Phone: 0300 123 6780
Email: developeras@lancashire.gov.uk
Your ref: 3/2025/0218
Our ref: 3/2025/0218/HDC/KW
Date: 12 May 2025

Location: Cherry Yate Stoneygate Lane Ribchester PR3 3YN
Proposal: Proposed 1.25m high garden wall and new gate piers set back 5.5m from highway.
Grid Ref: 365182 436114

Highway Development Control

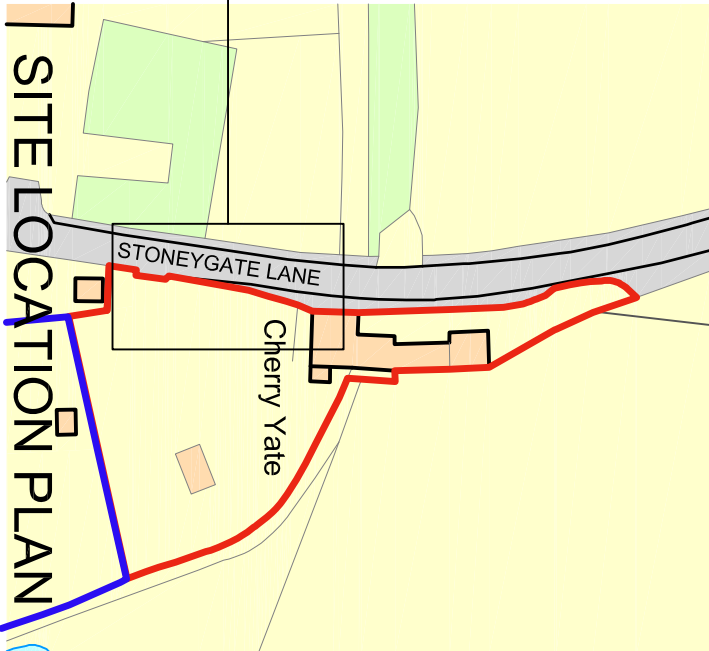
The visibility splay should be wholly within the land which the applicant controls and/or the adopted highway and nothing shall be erected, retained, planted and / or allowed to grow at or above a height of 1 metres above the nearside carriageway level which would obstruct the visibility splay of the existing access. This may result in a further reduction of the proposed 1.25m walls, should they fall within the visibility splay.

Existing and Proposed Site Layout Plans

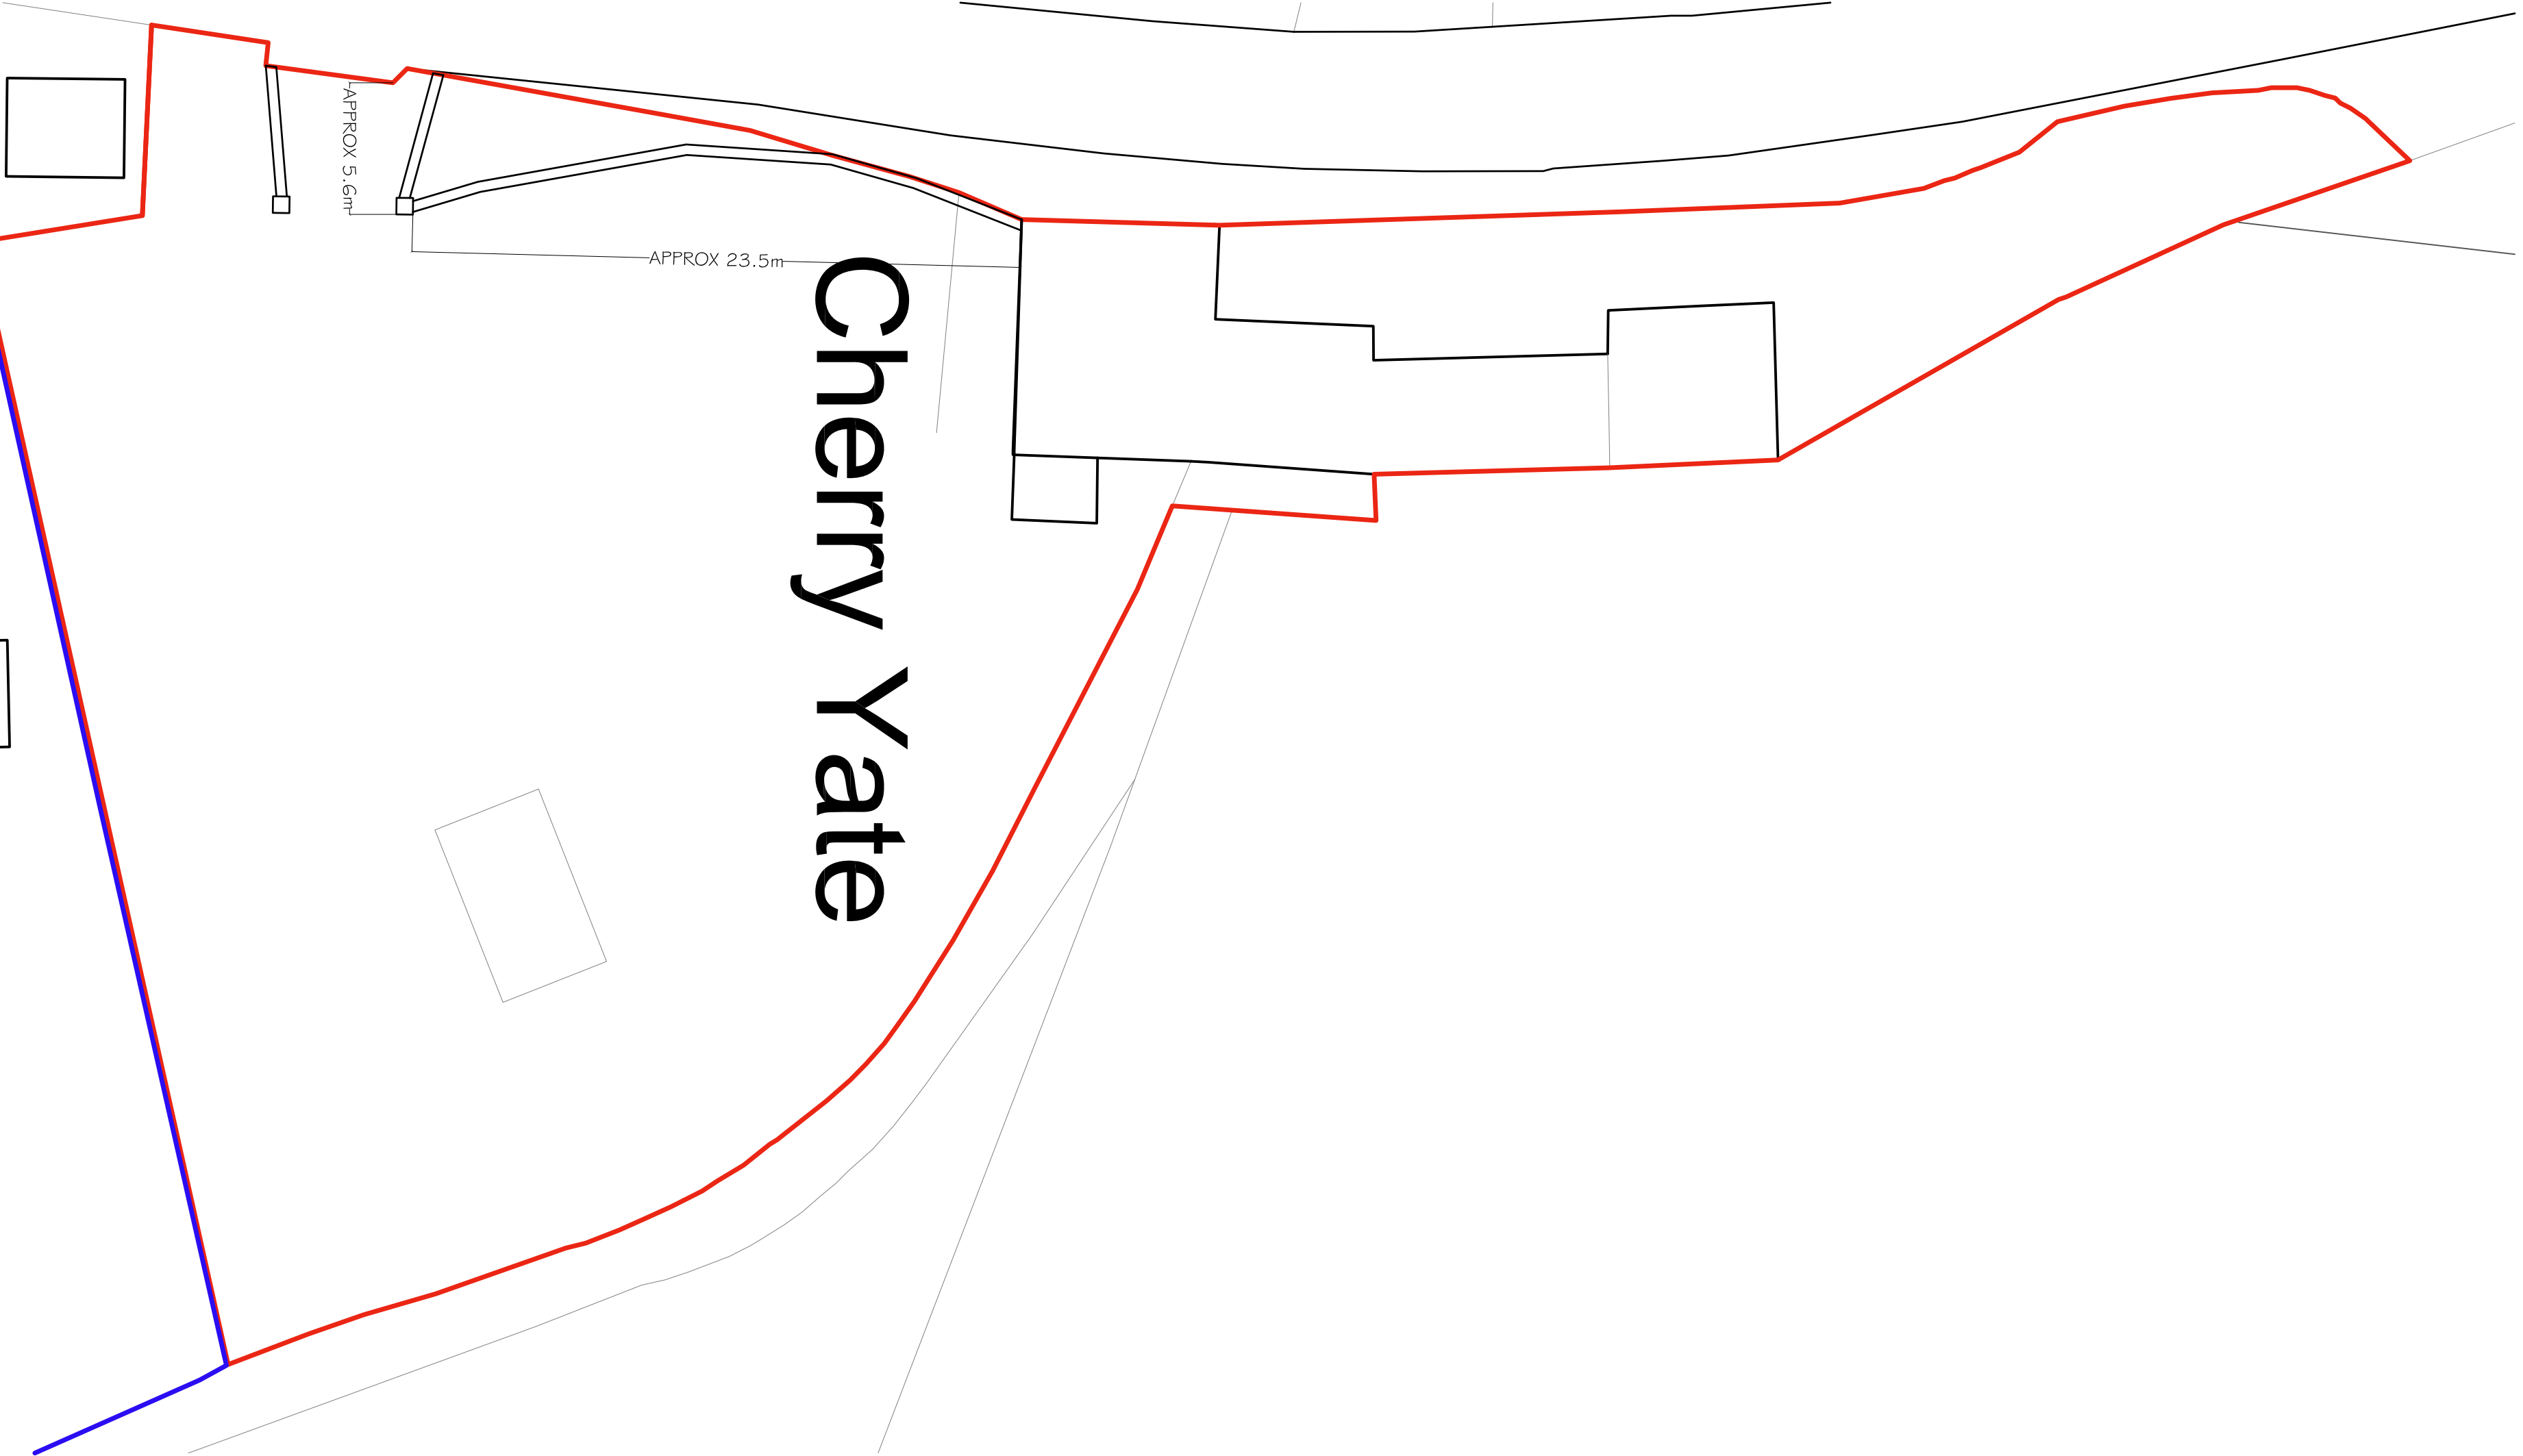
The LHA has reviewed the proposed site plan and notes that amendments are being undertaken to the boundary wall adjacent to the adopted highway. The proposal seeks to improve the existing access by setting back the gates and reducing obstructions in the existing visibility splay.

To ensure adequate intervisibility between highway users at an amended access a visibility splay set 2 metres back from the near edge of the carriageway and extending 215m to the nearside carriageway edge in both directions should be provided. However, given the existing nature of the access, the LHA would look for the maximum visibility splay achievable.

In conclusion, the LHA require a drawing showing the maximum visibility splay possible at the site access; any walls or vegetation which falls within the visibility splay should be removed or reduced to no more than 1m above the carriageway level.
